PLAN-020727

Proposal: 5 No. residential units (resubmission following LY/9/17/PL).

Site: Roseland, The Causeway, Arundel, BN18 9JL.

LY/25/17/PL

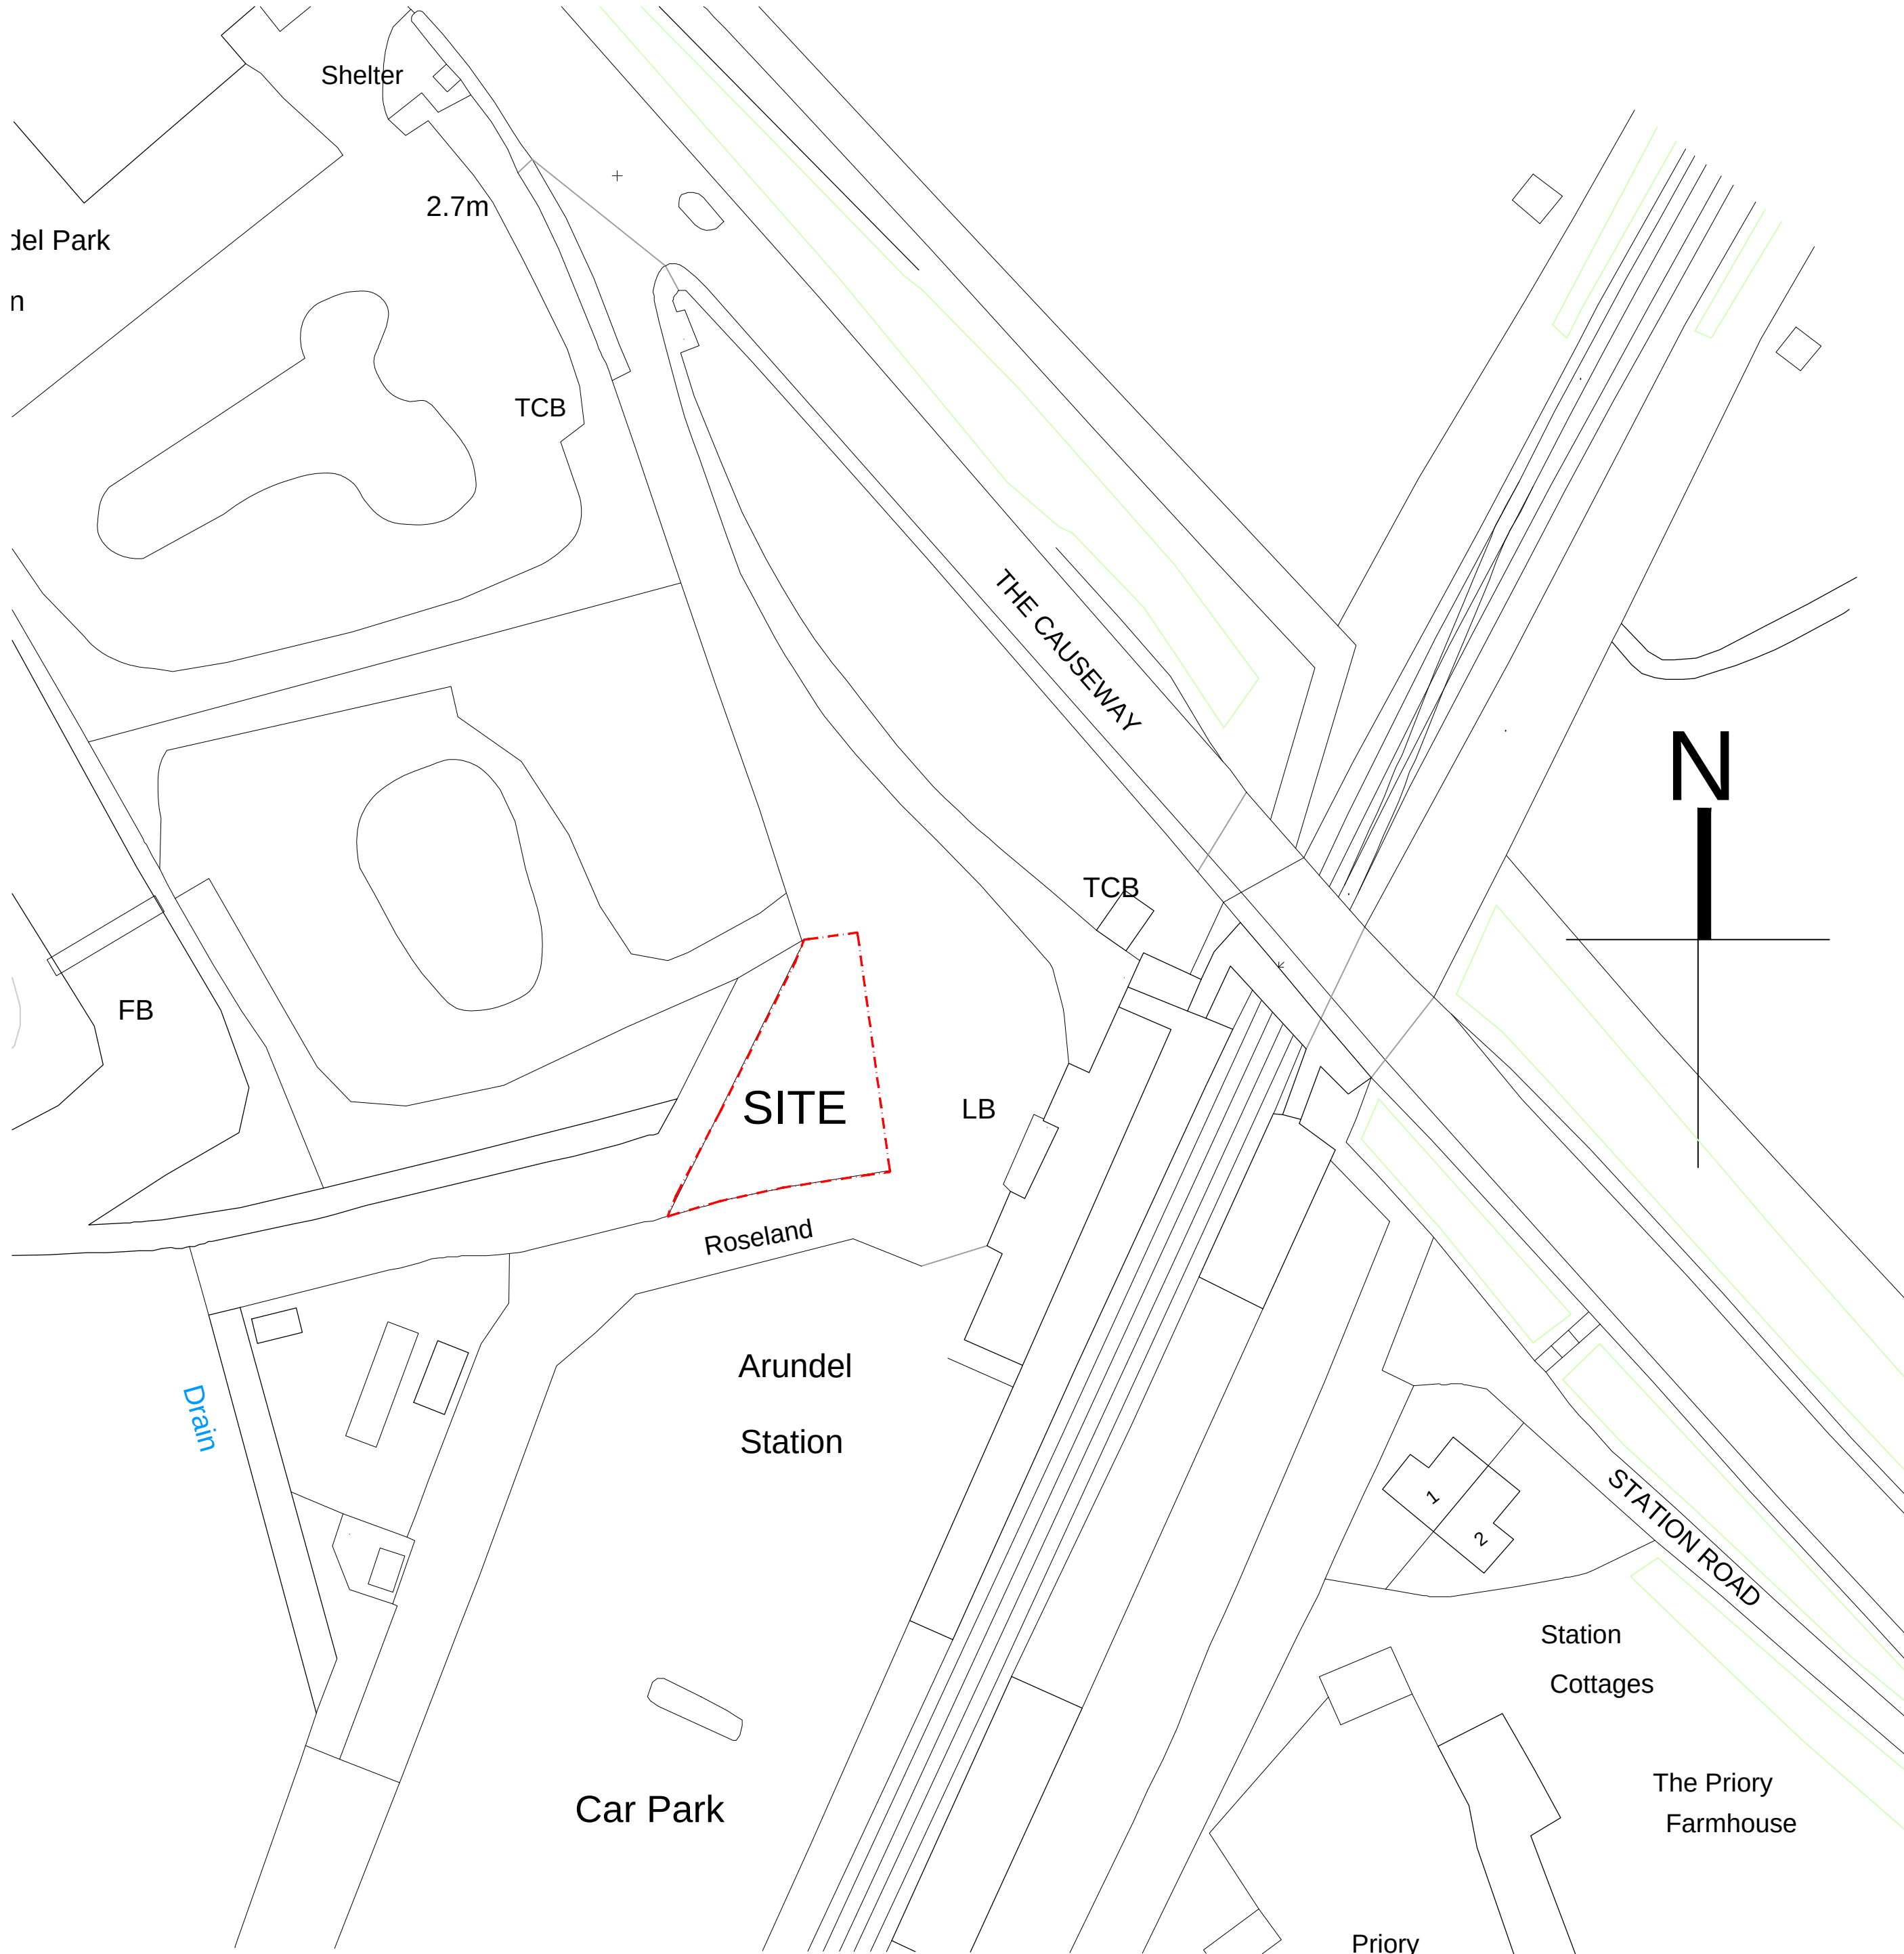
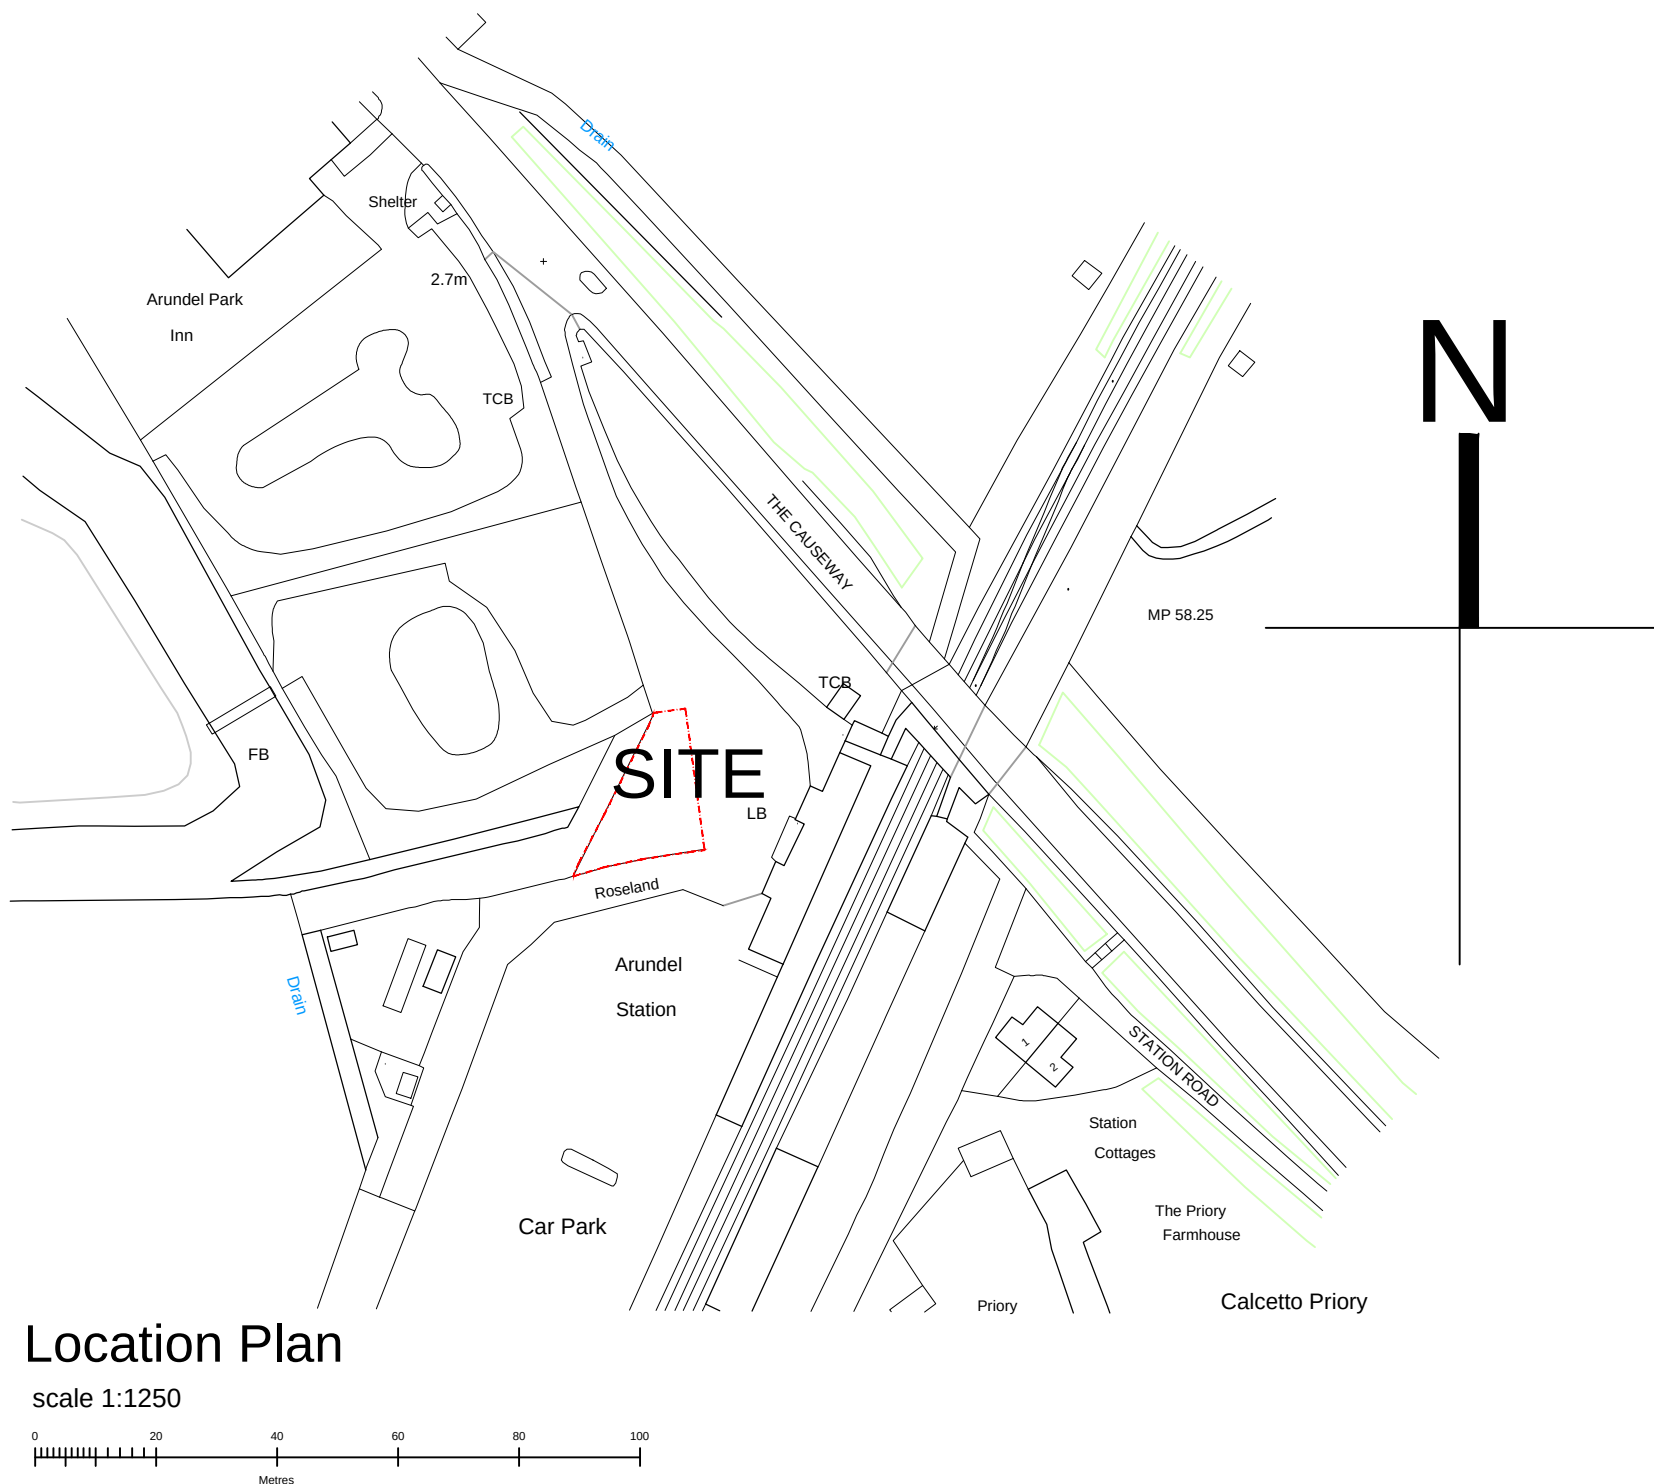
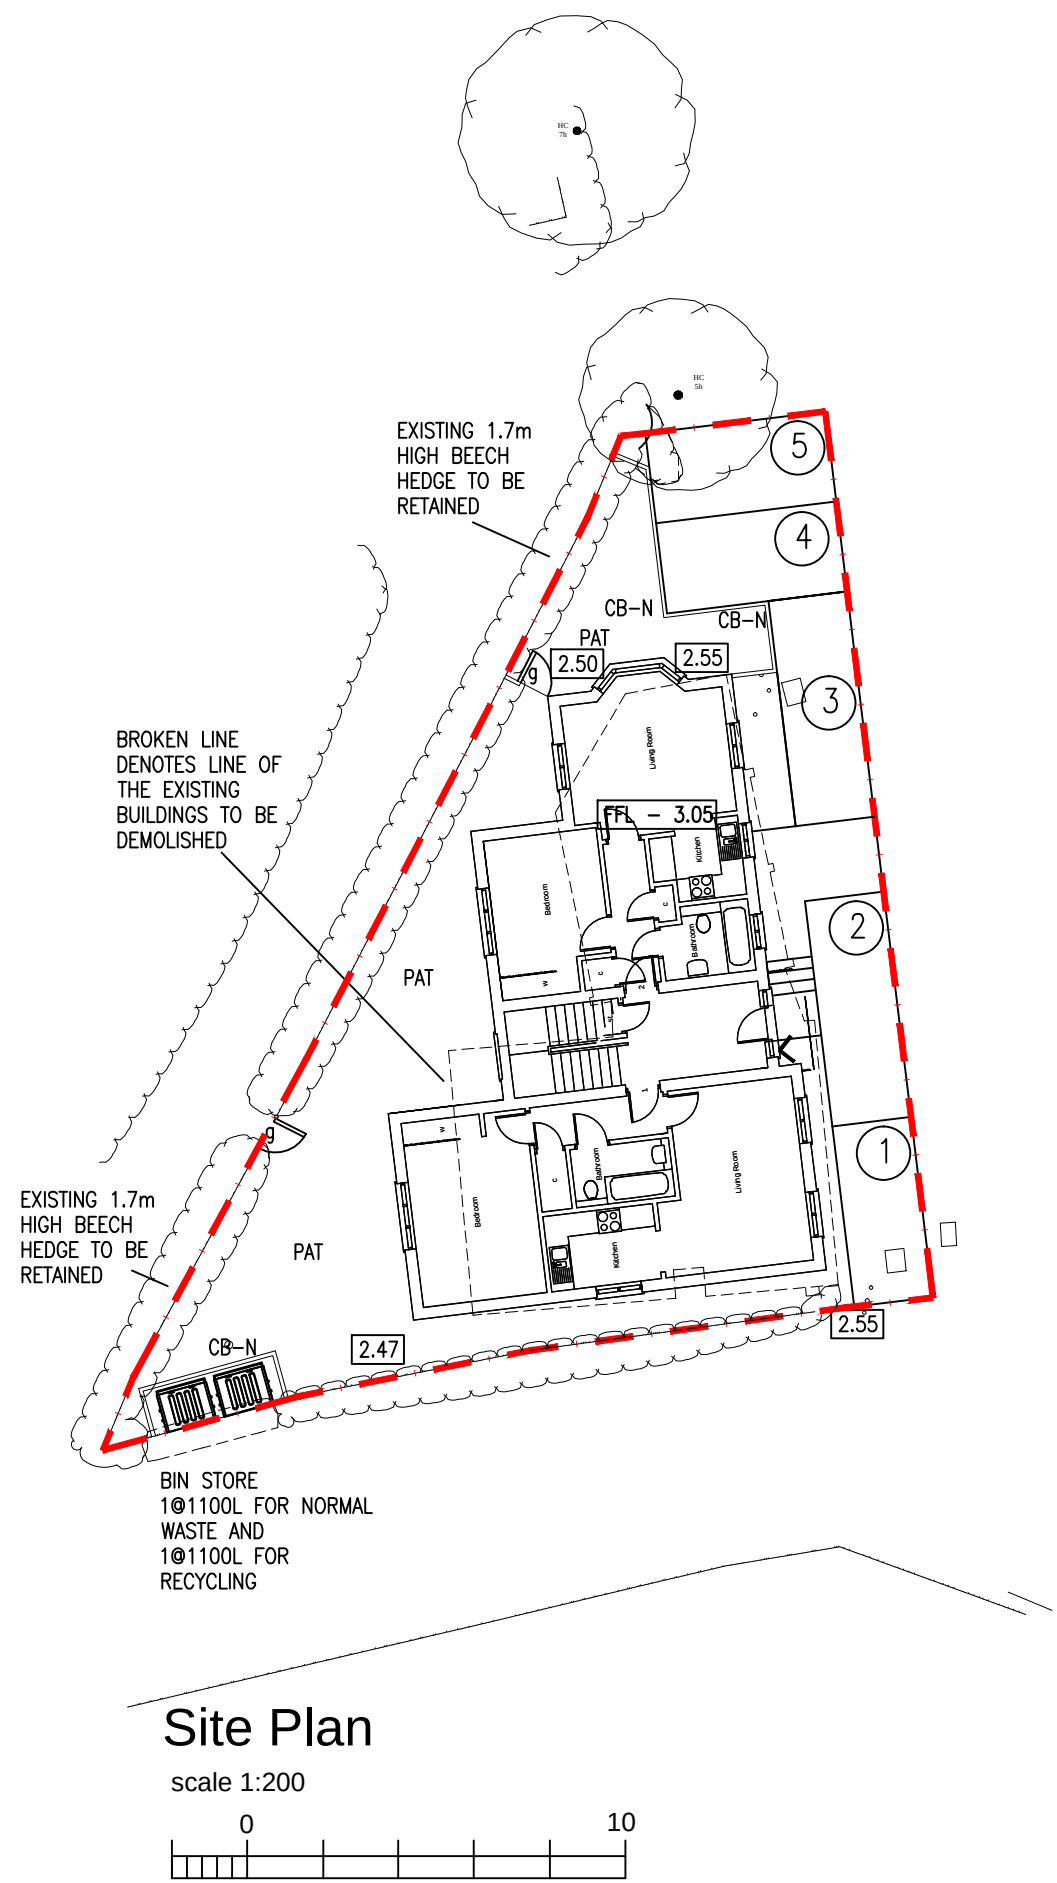
Please note the submitted drainage layout shows surface water culvert within the site (not shown on our records). The district council should be contacted with regards to the surface water culvert crossing the site.
